# CITY OF ALBUQUERQUE

March 14, 2013

**Re: Mesa Del Sol Montage Unit 2, Portrait Park Swimming Pool  
Grading and Drainage Plan  
Engineer's Stamp date 03-04-2013 (R16/D003B)**

#### GRADING AND DRAINAGE PLAN

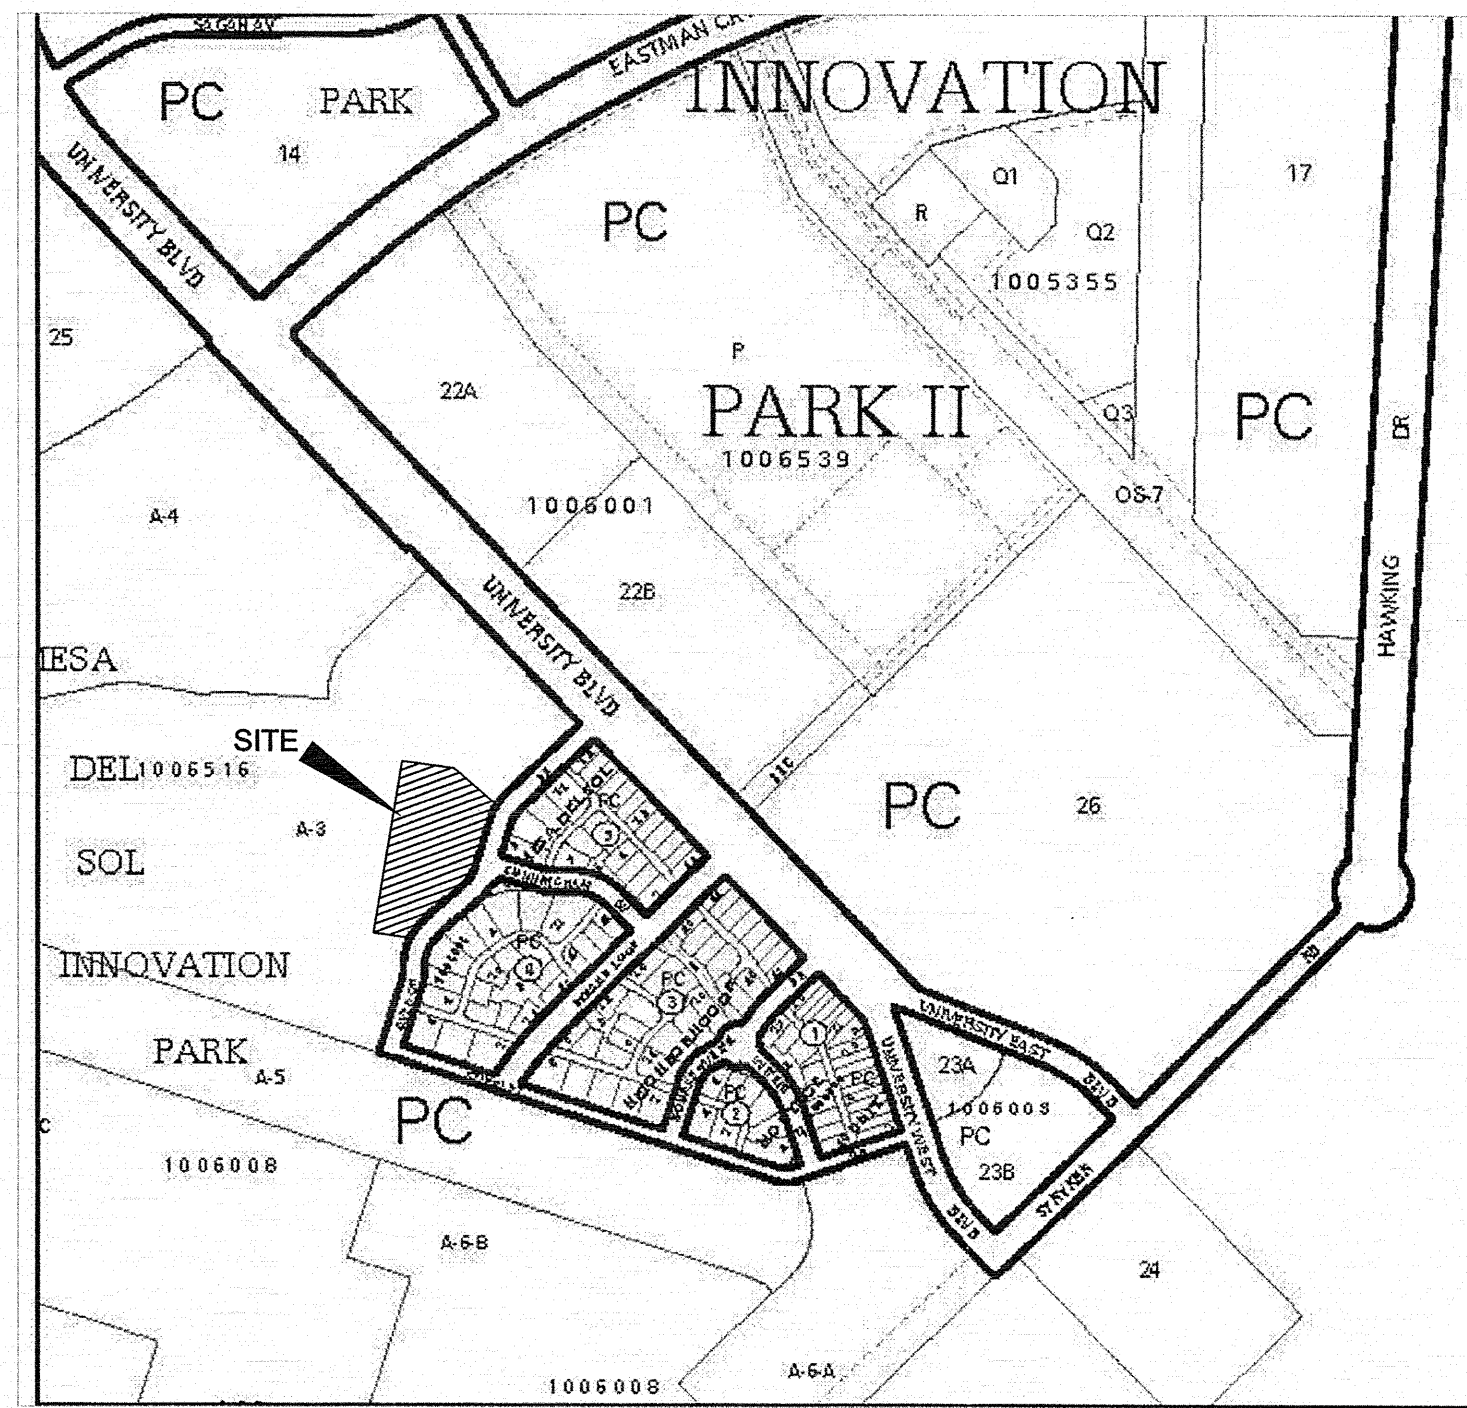
- Please provide further clarification on the status of construction activities along Penn Avenue; are the sidewalk, curb and gutter already installed and if not, will these activities be completed prior to the construction of the proposed sidewalk culvert as part of the Work Order.

- Provide an additional note to the sidewalk culvert stating that all bolts are to be tack welded to the steel plate and that the culvert should extend 2' back from the property line.

- Capacity and sizing calculations for the proposed sidewalk culvert are required.
- Will the project require a paved parking lot or any drive pad entrances along either Avedon Drive or Penn Avenue? It appears that the drainage plan intends to discharge flows directly over the sidewalk along Avedon Drive and portions to the east and north of the swimming pool.

- Are any offsite flows accepted from the southern portion of the project site?
- Where do the discharged flows ultimately end up once they enter Penn Avenue & Avedon Drive? Have the pond volumes for the unit in question been certified?

- Flowline elevations for each of the streets adjoining the project site need to be included on the grading plan.
